Subject: FW: Document Issue No. 13 - P16-063 - Walberton Place Care Home, Arundel

P16-063 - Walberton Place Care Home, Arundel Issue 13

Title
PROPOSED DRAINAGE & EXTERNAL WORKS LAYOUT (SHEET 2 OF 2)

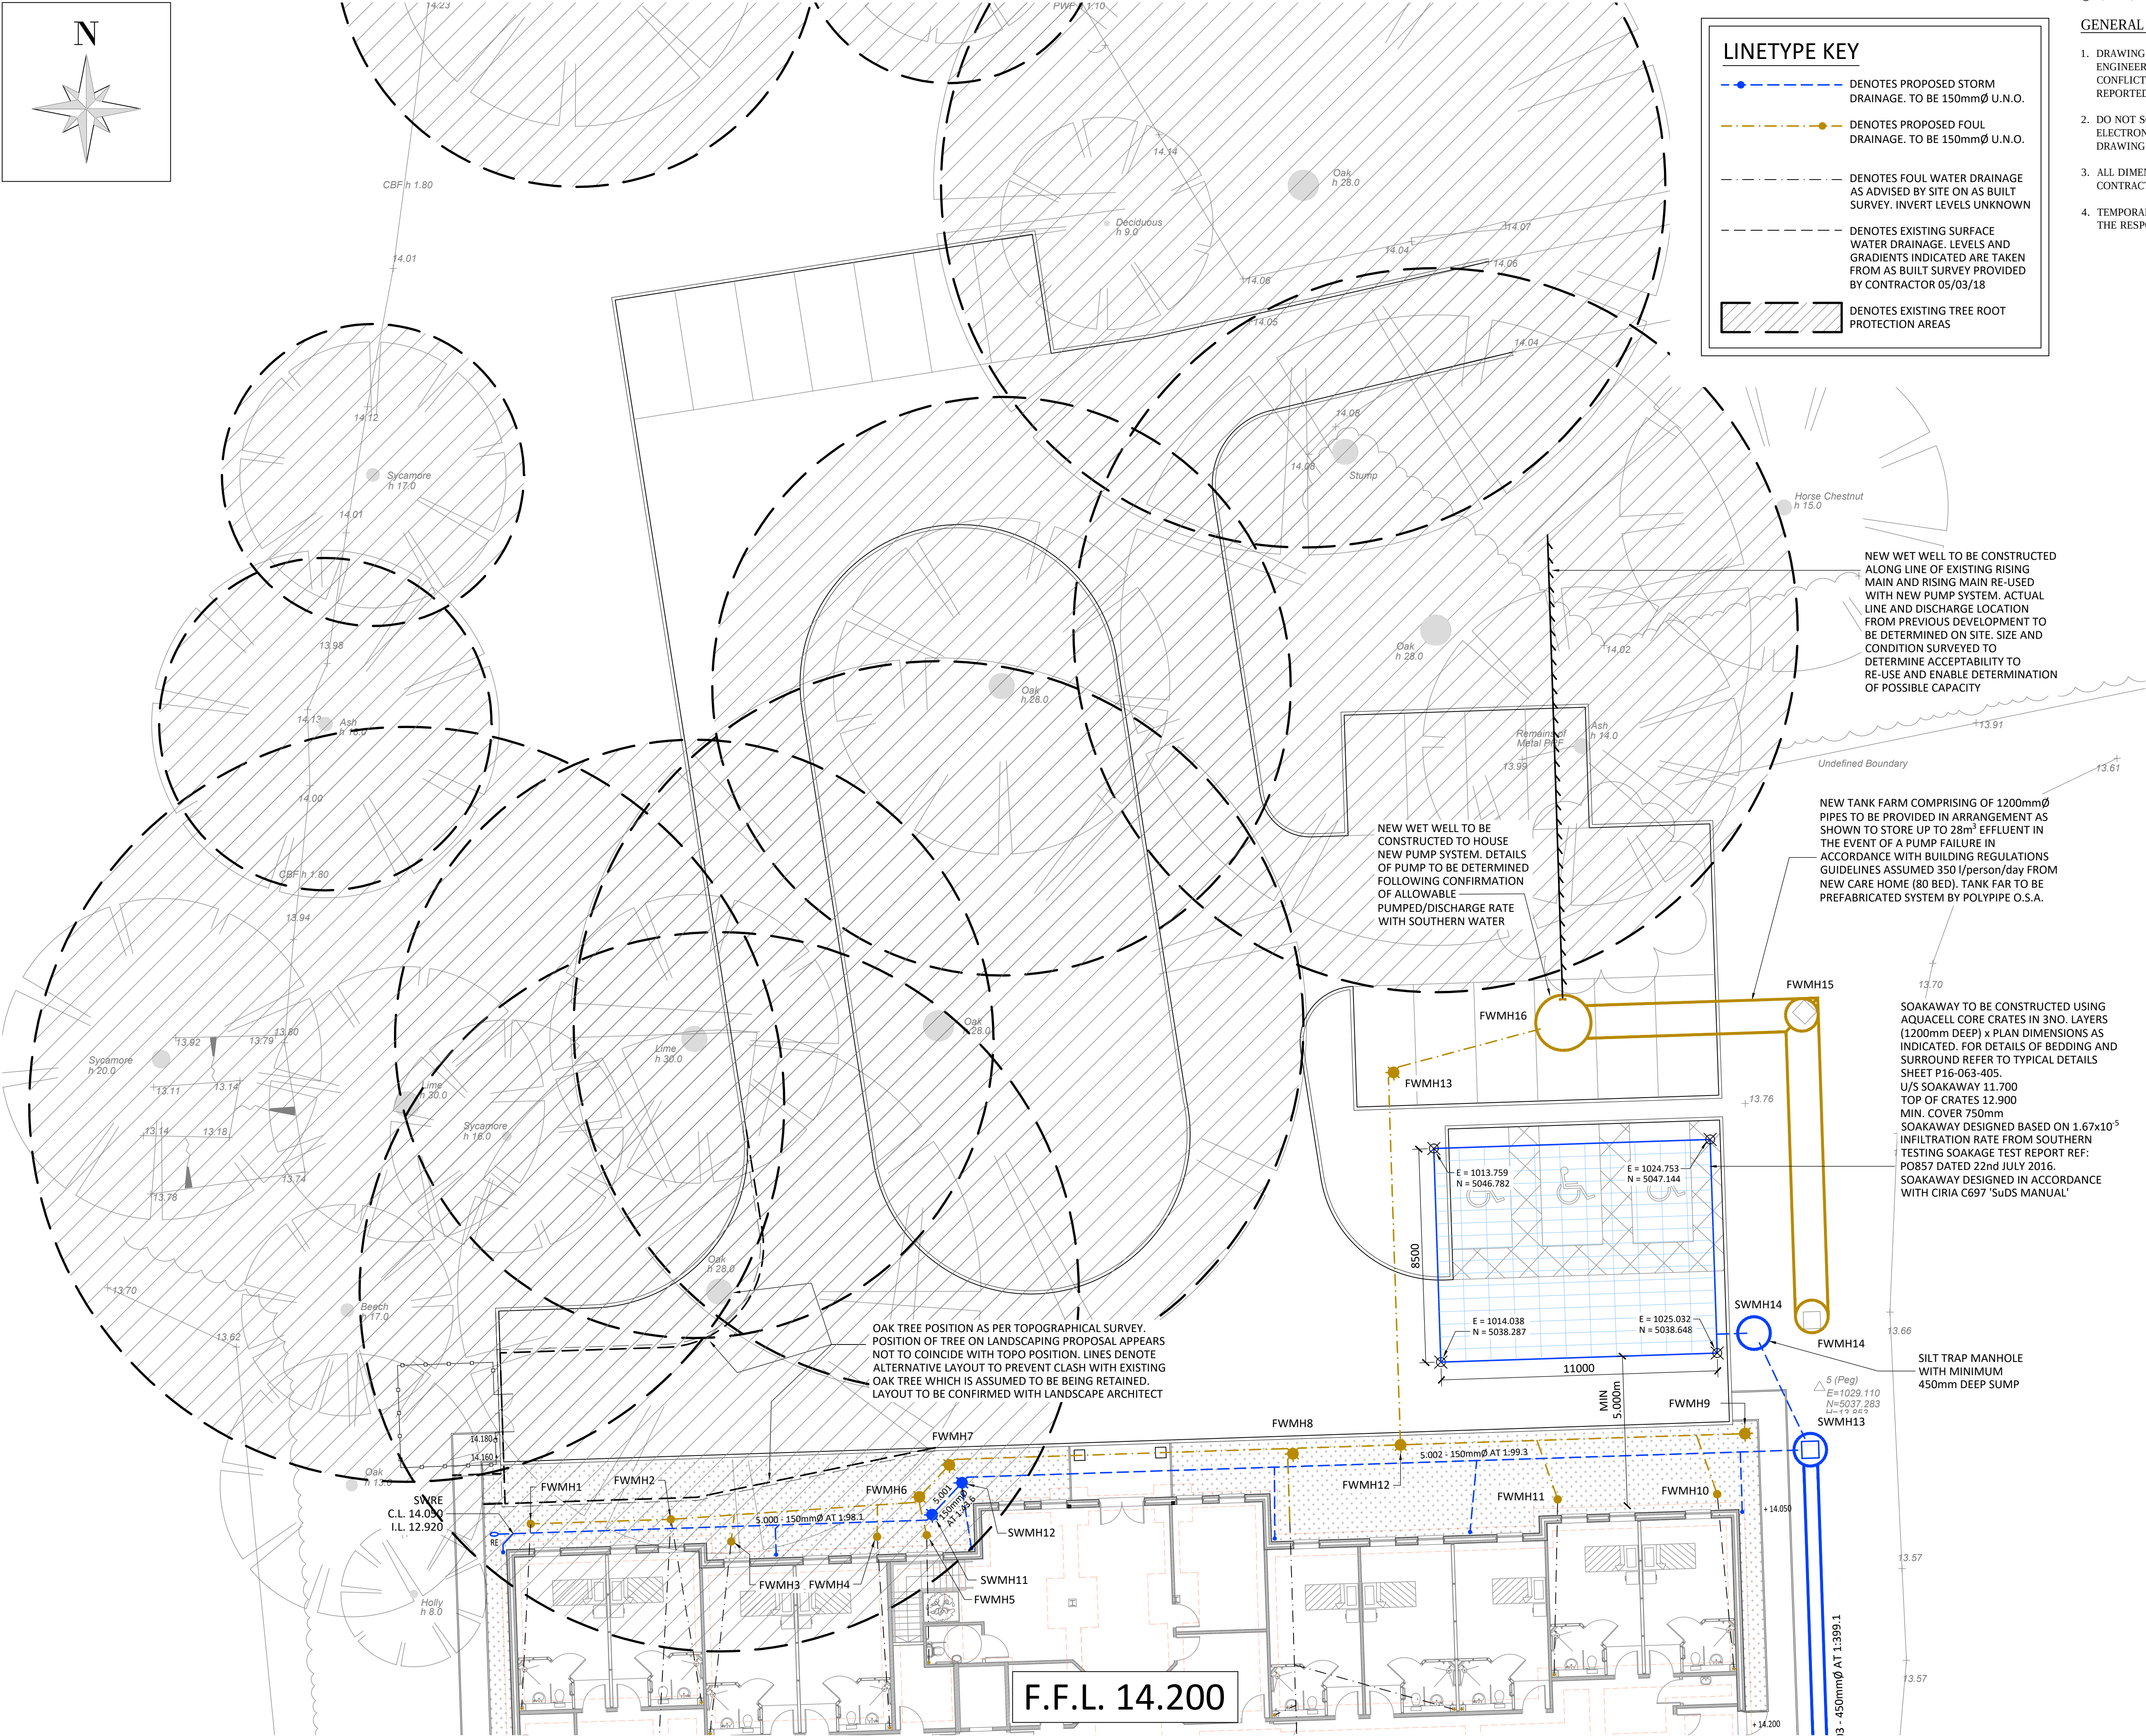
Yes, your proposal to just have a sump chamber prior to entering the soakaway is okay, as long as this has a decent sump. i.e. 450mm.

1. Currently the surface water attenuation tank within the courtyard has a plan area of 32m² not 42m² used in calculations. Please revise the calculations.
 2. For the design of the soakaway please apply the infiltration coefficient to the sides of the tank only, and not the base. I.e. reverse what is currently used, and adjust the infiltration area as required.
- As this will likely have a significant impact upon design, I will provide further comment to your responses once the design has been revised.
- Let me know if you have any questions.
- Regards,

6. There seems to also be room to the west and north of the soakaway why can this not be utilised to make the soakaway bigger? I have made the soakaway a little larger however am hesitant to increase it much further.

7. The construction detail drawings need to be updated. And manholes need to have 300mm deep sumps. All manholes requiring sumps seems a little excessive. I have proposed a sump chamber prior to entering the soakaway, will this not suffice?.

I have had a chat with my colleague Paul, and we will let you use infiltration through the base in this case, as we do want to avoid pumping.

In terms of the soakaway, it was our approach to design to Ciria C697 SuDS manual criteria which allows the inclusion of the base area. Given the sands and gravel substrata under the clay surface layer this was thought to be a suitable approach given our limited space.

Title
PROPOSED DRAINAGE & EXTERNAL
WORKS LAYOUT (SHEET 1 OF 2)

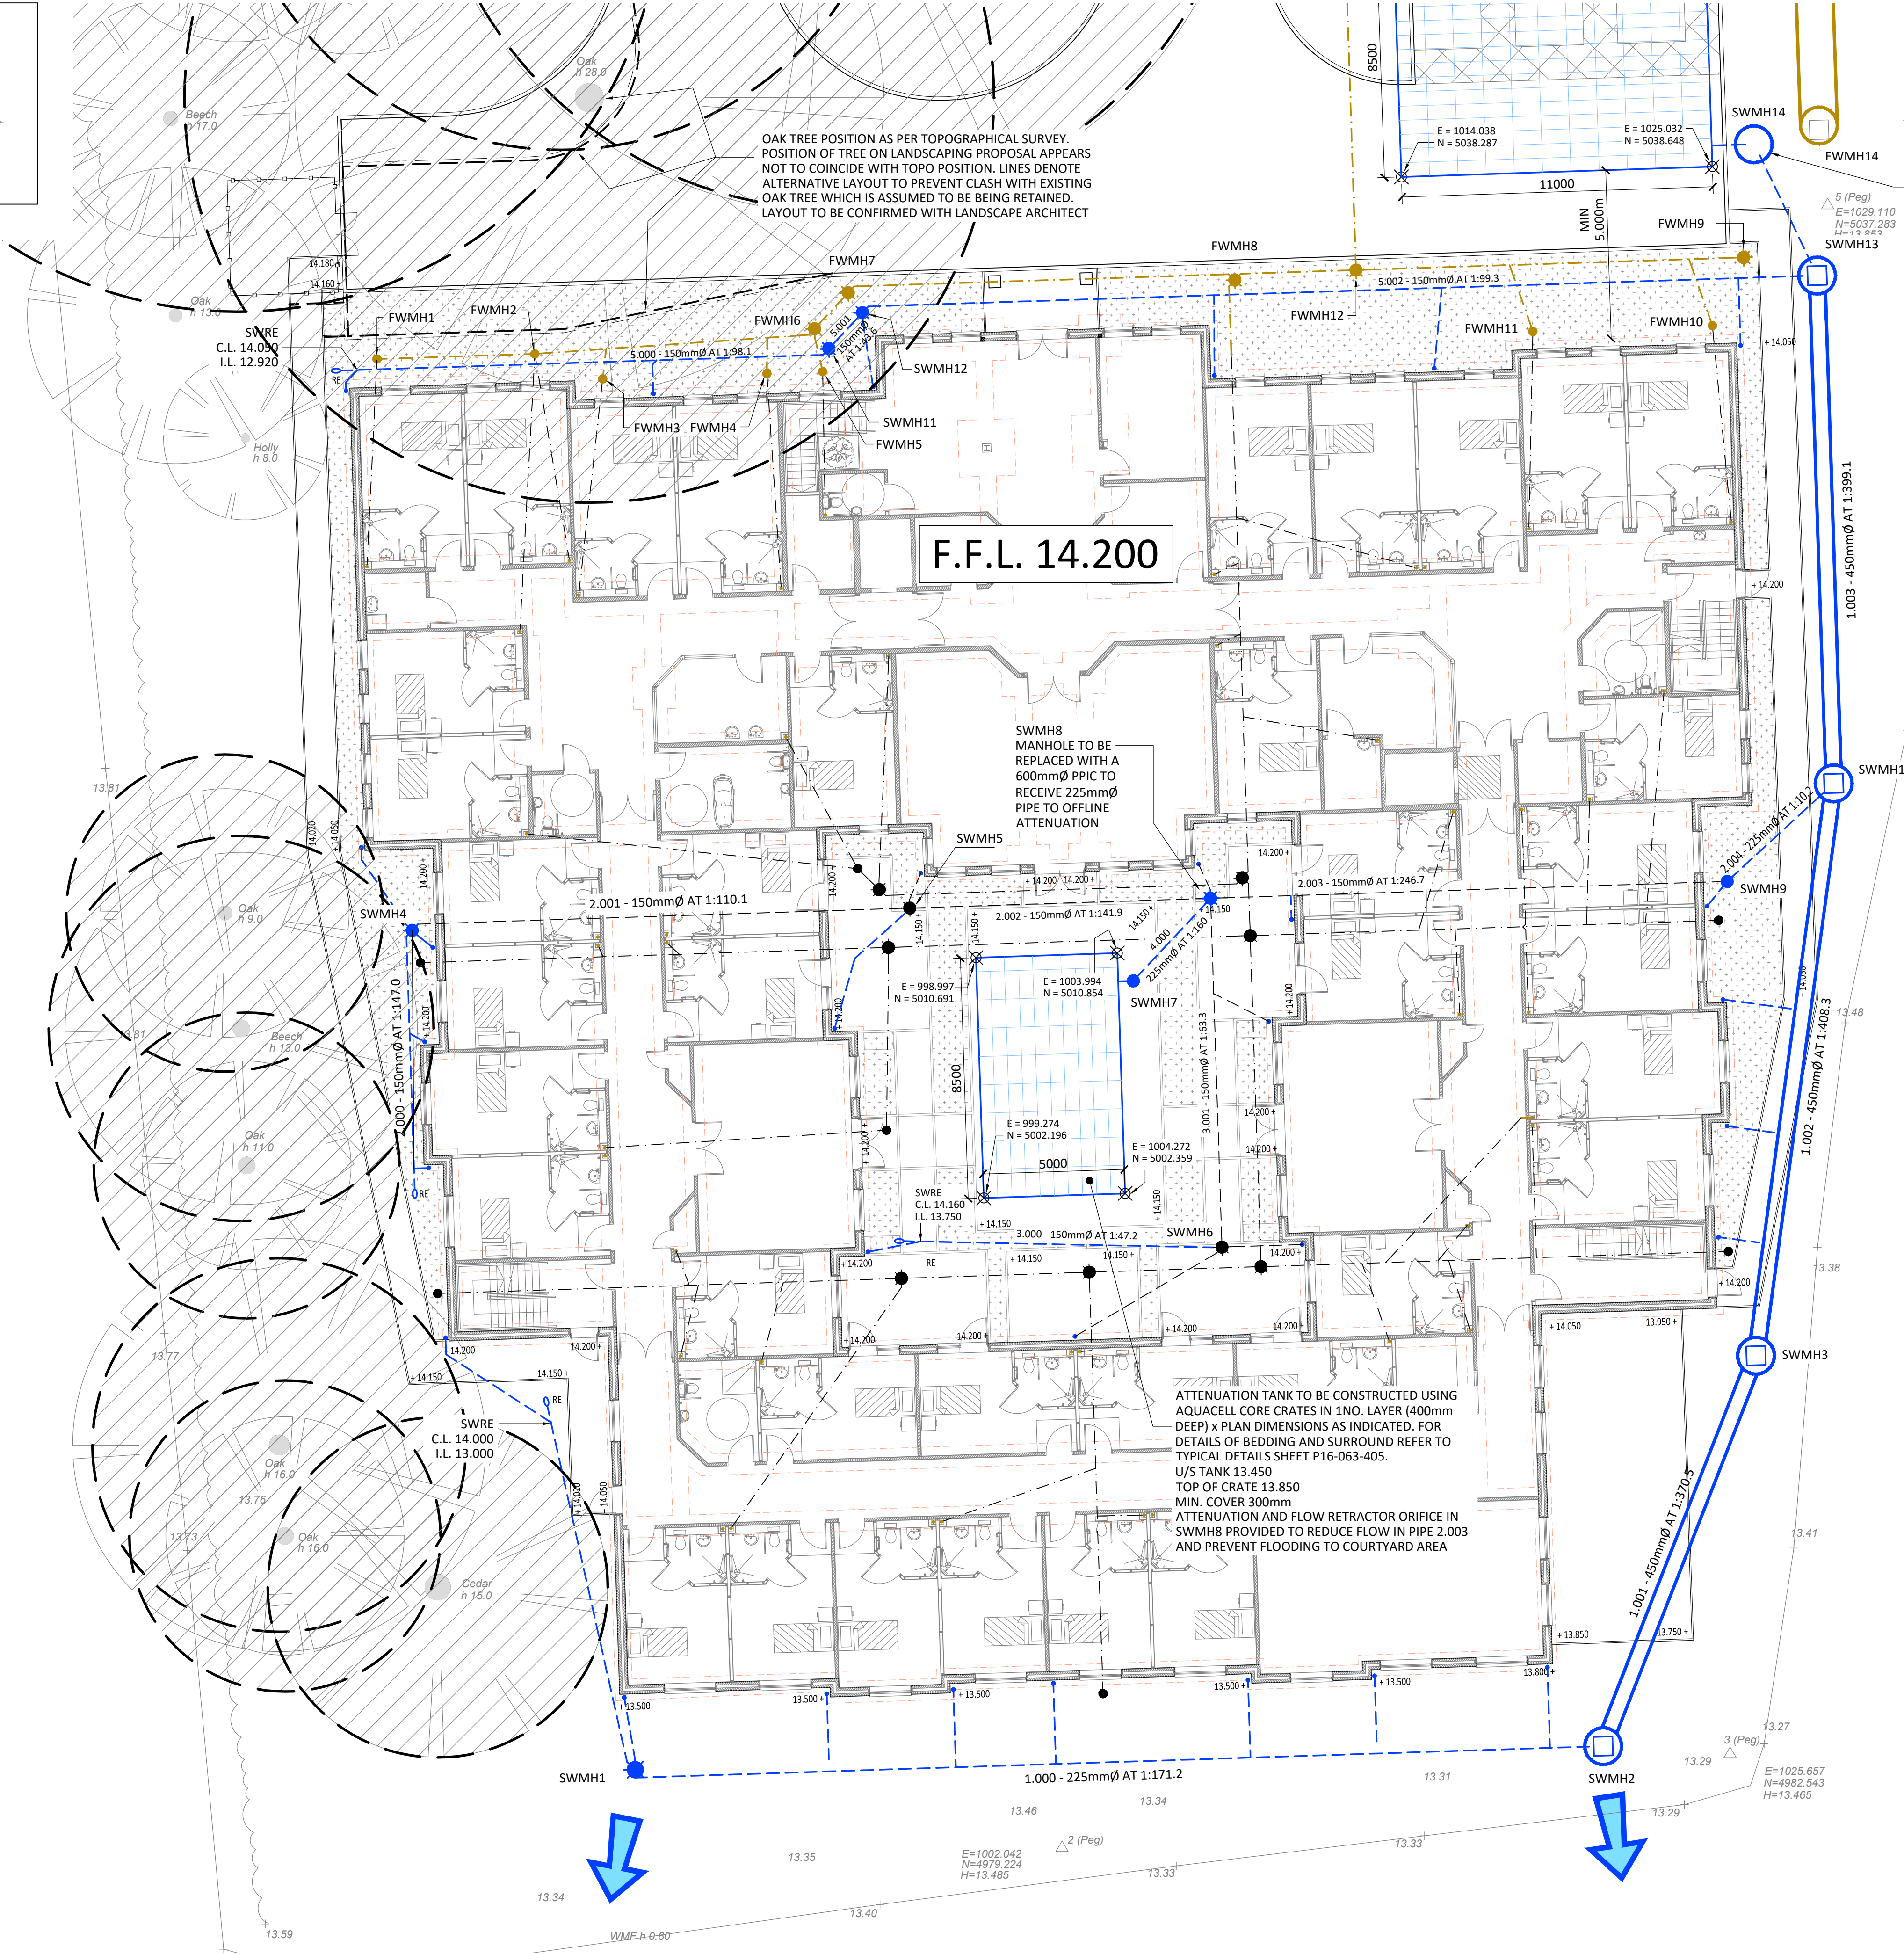
1. I see that the system is significantly surcharged. I am a little concerned about this. Especially network 2 where maximum modelled water levels are exceptionally close to the cover levels of the manholes. Is it possible to oversize the pipe for 2.000 so that some more on line storage is provided? I realise this will reduce velocities in the pipes for low flow conditions, but I am less concerned by this than water levels within 4mm of cover levels. I have reconfigured the roof areas and redirected a portion of roof away from pipe 2.000 in the aim to reduce the surcharge extent on this system. As you can see from the revised calculation that the flood risk is now only up to 165mm beneath the cover level instead of the previous 4mm as you quite rightly mention in your comment. Hopefully this can now satisfy your concerns over this.

2. Looking at the calculations the restriction on flow for this network is pipe 2.002, this pipe is an existing pipe I believe, could this be replaced with a larger pipe? In which case point 1 may be resolved. Pipe 2.002 could be increased, however the restricting pipe length is in fact 2.003 which runs under the building footprint. Unfortunately this is constructed and changing this length will prove difficult. This was the main reason I introduced the flow restrictor prior to this pipe to try and limit the flow travelling along it. I have however now removed this orifice restrictor.

3. The offline attenuation tank could be increased in size to also try to get reduced maximum water levels. The offline attenuation can not get any bigger as it is very shallow at the moment and I would prefer to keep it within the soft area within the courtyard.

4. The fall on the majority of the network is currently not meeting the 1m/s self-cleansing velocity. Why does network 1 have to start quite so low? Can it not start higher and therefore increase the fall. I realise the pipe will then need to be covered in concrete, but the fall does need to be increased if possible. I have tweaked the system to ensure that all of the new pipework will achieve the 1m/s velocity. I agree this is necessary and should have been incorporated at the outset. The tweaks have only amounted to a few millimetres per run. The only pipe not achieving the 1m/s velocity are the existing pipes within the building courtyard area. However as previously stated, changing these now will be problematic. The reason the main run needs to start so low is because the ground level to the south west corner of the site are somewhat lower than the rest of the development which is why the invert needs to start at the lower level.

5. The oversized pipe network seems really large. Would it not be more efficient to put an additional attenuation tank between MH2 and MH3? The oversized pipework is 450mm diameter. In reconfiguring some of the roof drainage I have been able to omit the length running along the southern boundary and replace this with a 225mm diameter pipe. However, as you can see from the calculations, the attenuation is required, therefore as manholes and pipes are required regardless it seemed more practical to slightly oversize them as opposed to introduce additional crate tanks.

8. Could you also provide exceedance flow routes on your drawings, so that we can see that these routes and the accompanying risk to the building has been considered. The low point of the development is the south west corner where the ground levels are somewhat lower than the remainder of the development. This is where any exceedance will appear and will run south across the adjacent fields away from the development. This information has been added to the drawing.

My calcs are based upon an attenuation tank of 42m² therefore it is the drawing which needs to be changed to reflect. I think this is just down as a typo.
